Our Ref: TR040011

Application by North Somerset District Council for an Order Granting Development Consent for the Portishead Branch Line – MetroWest Phase 1

Advice following issue of decision to accept the application for Examination

Cut Line For Continuation See Sheet 9

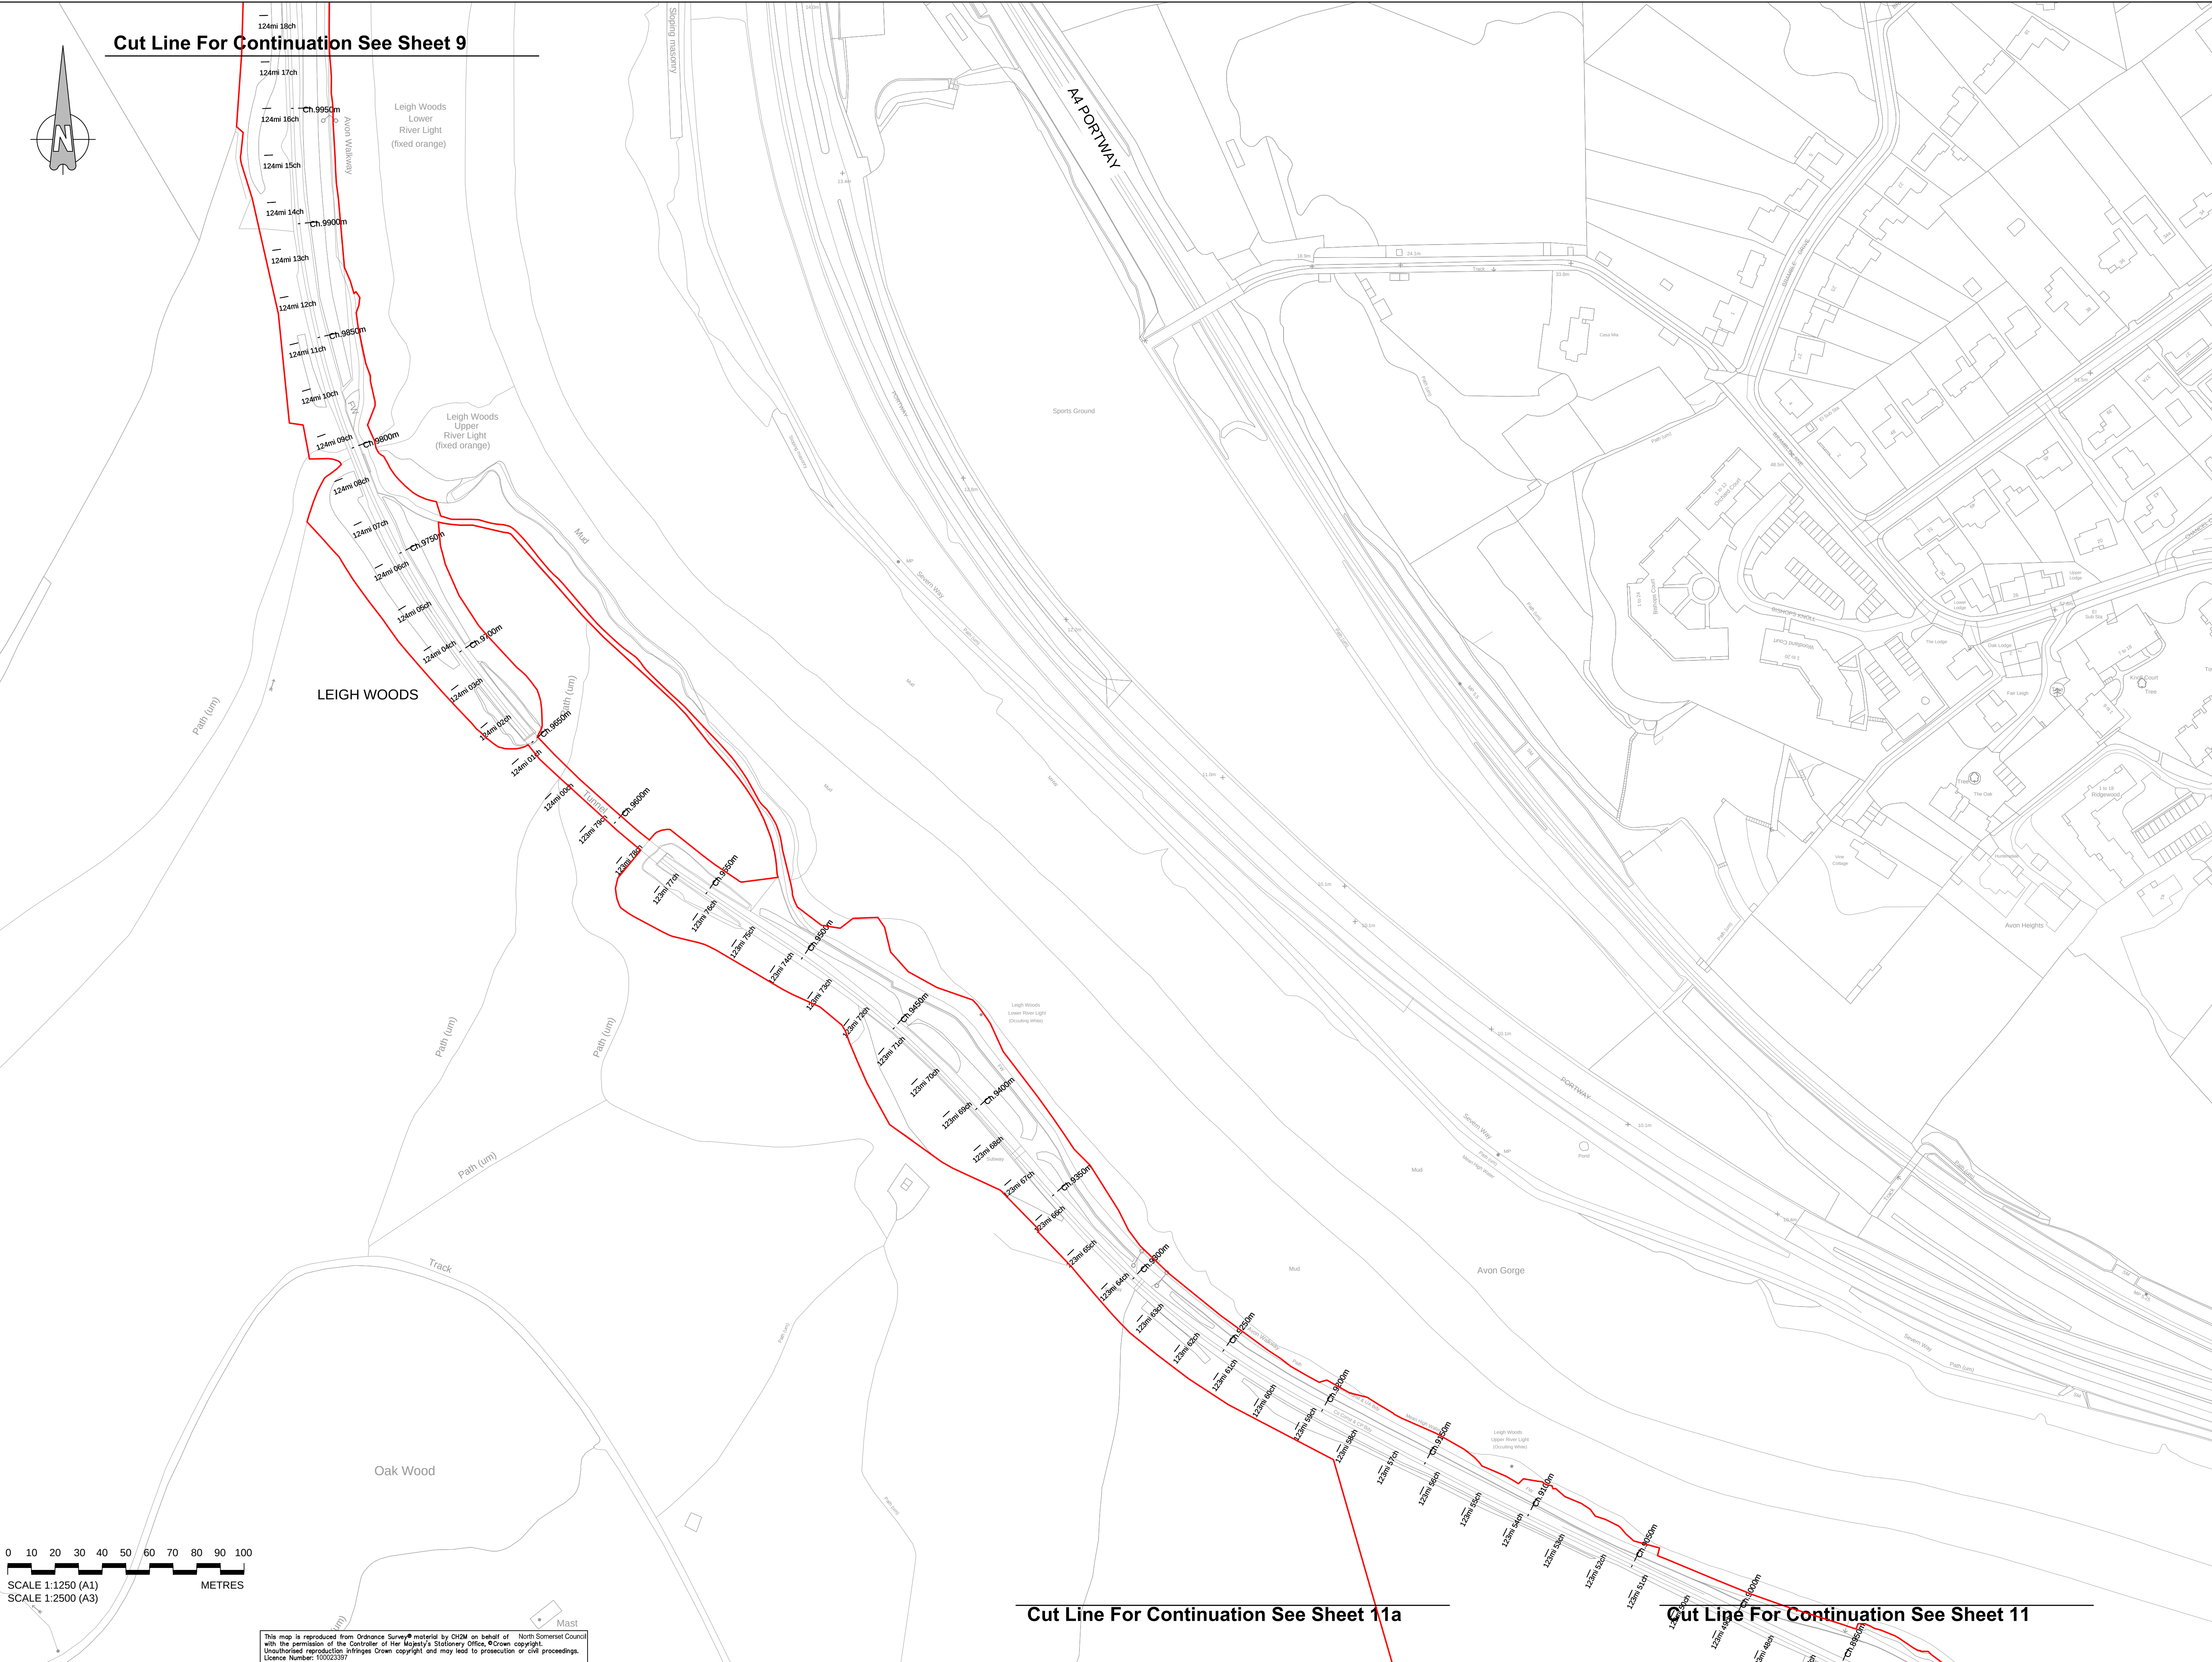
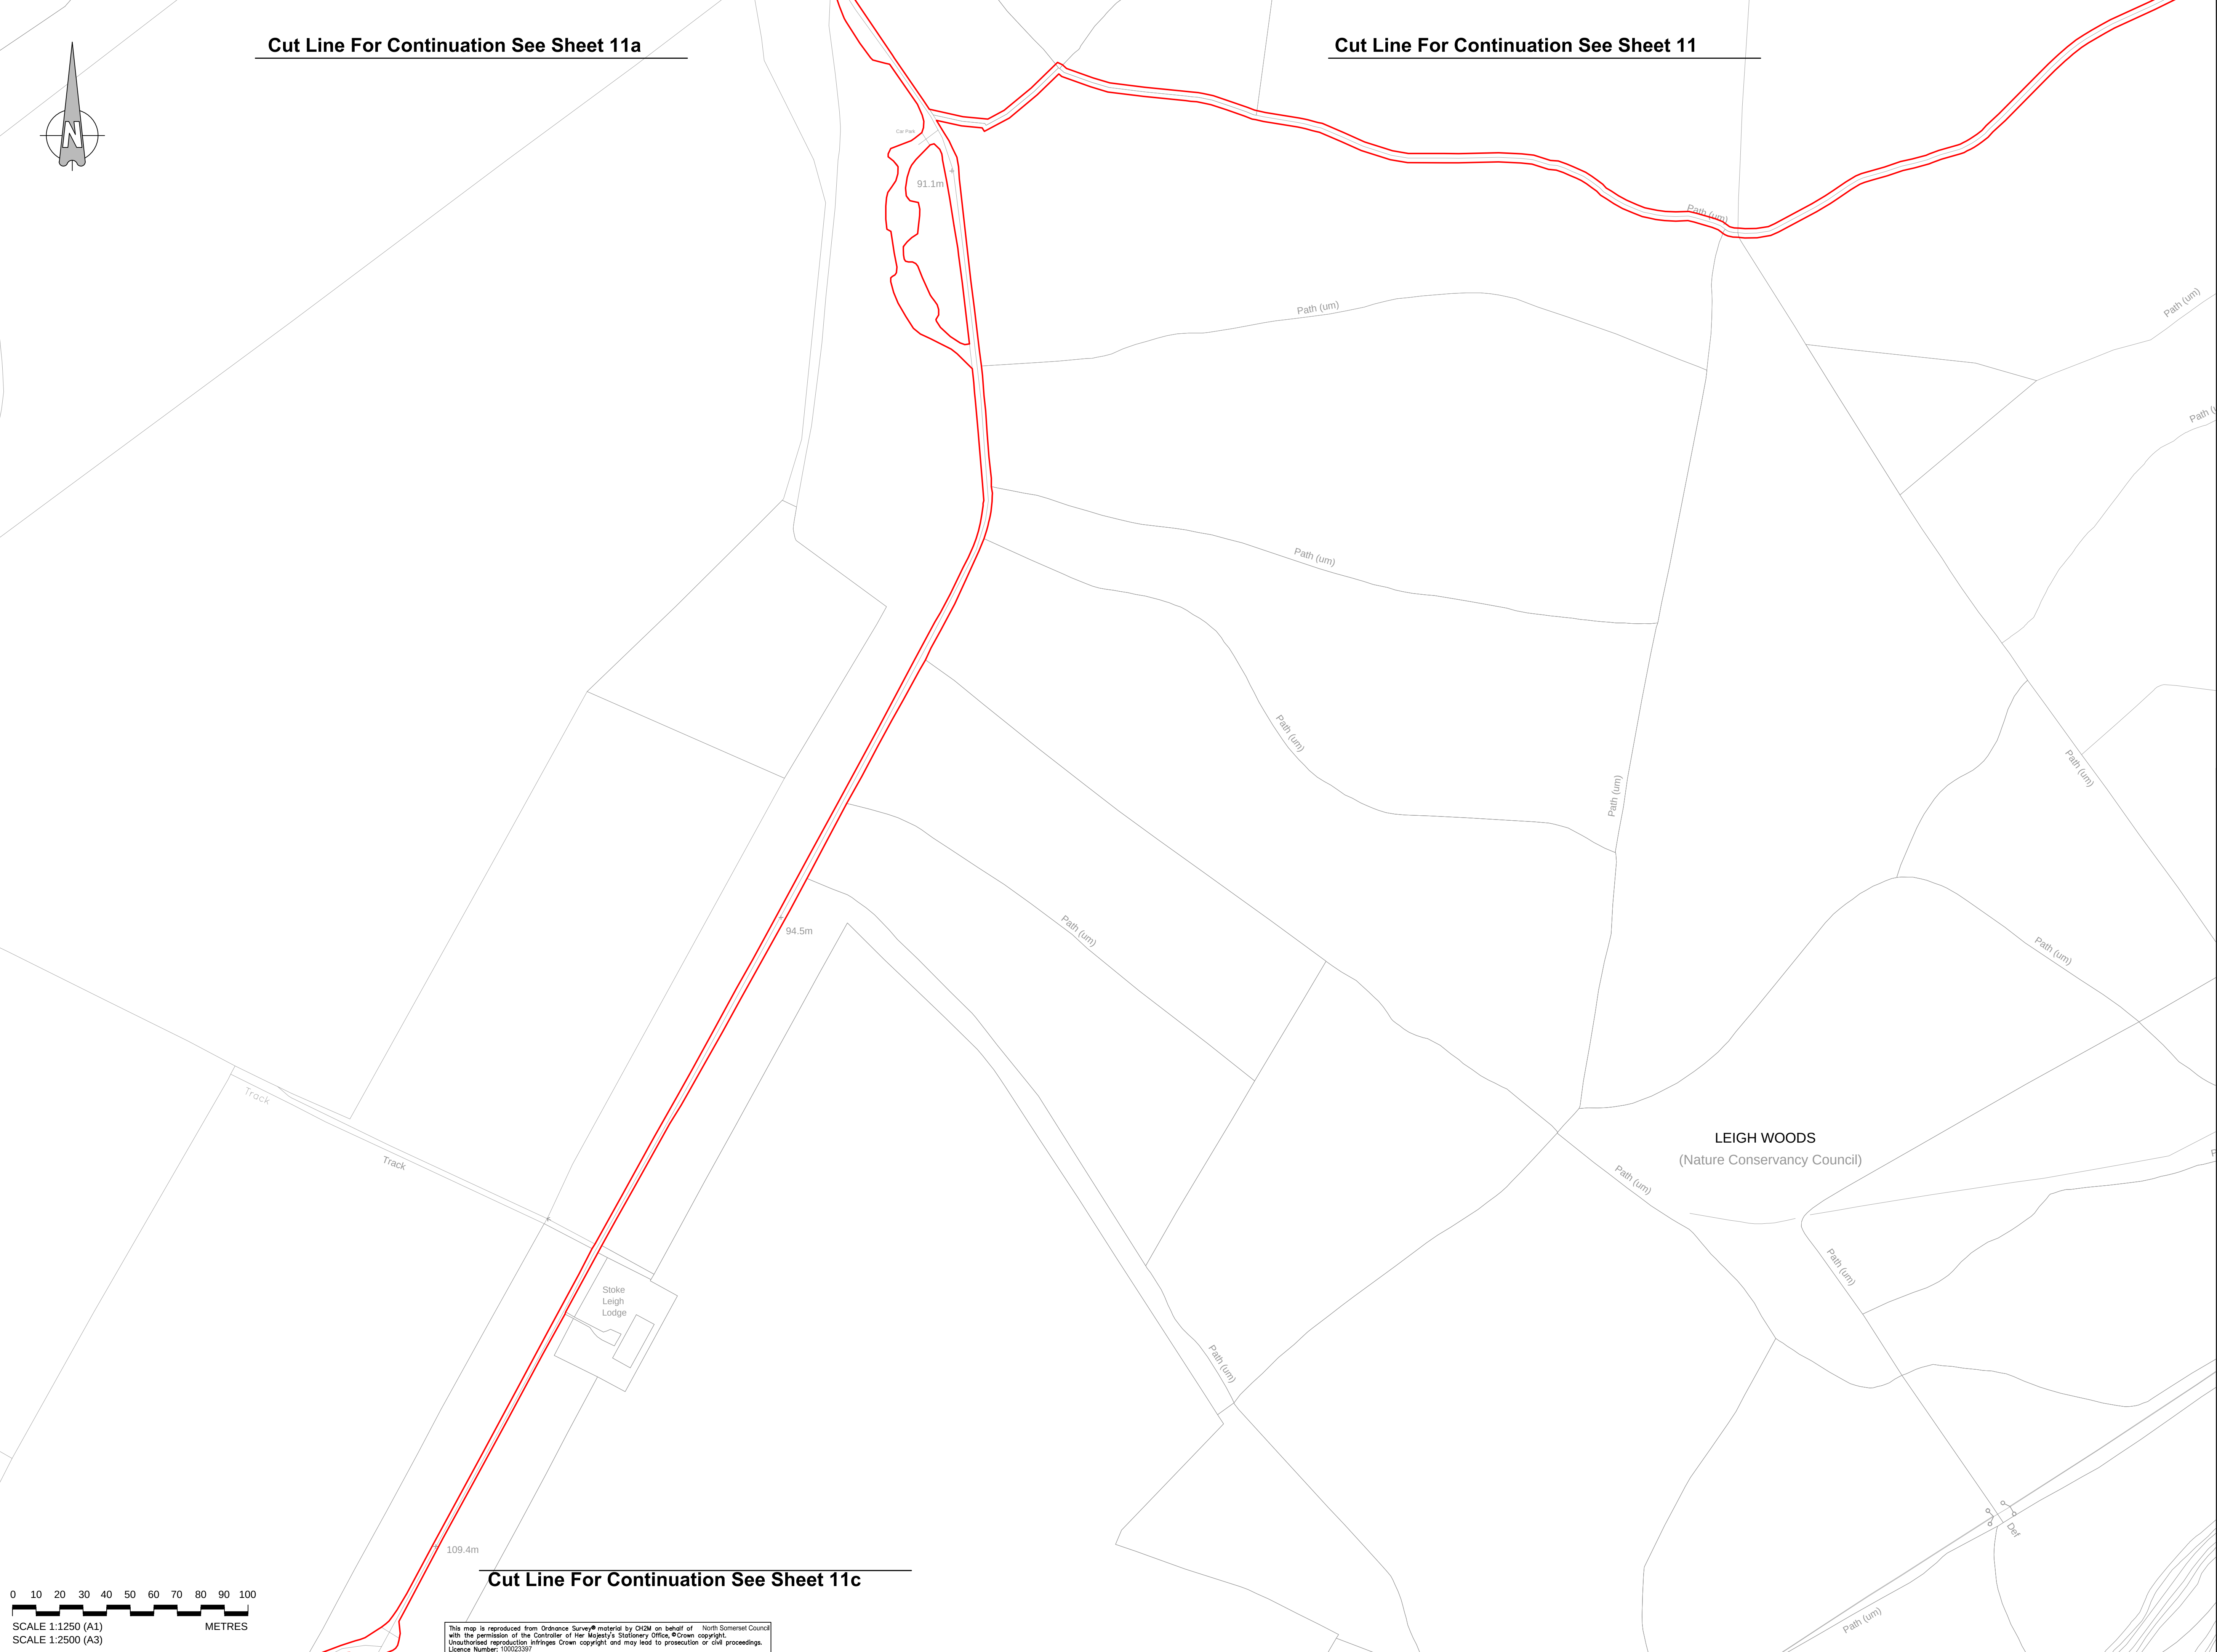
There are also inconsistencies between the Description of the Works in Schedule 1 of the draft Development Consent Order and the Works Plans (**Doc 2.3**) (eg Works Plan 2a, 7e, 13a).

The Applicant is advised to carry out a comprehensive check of these documents to ensure all information provided is complete and accurate and provide updated documents, if required.
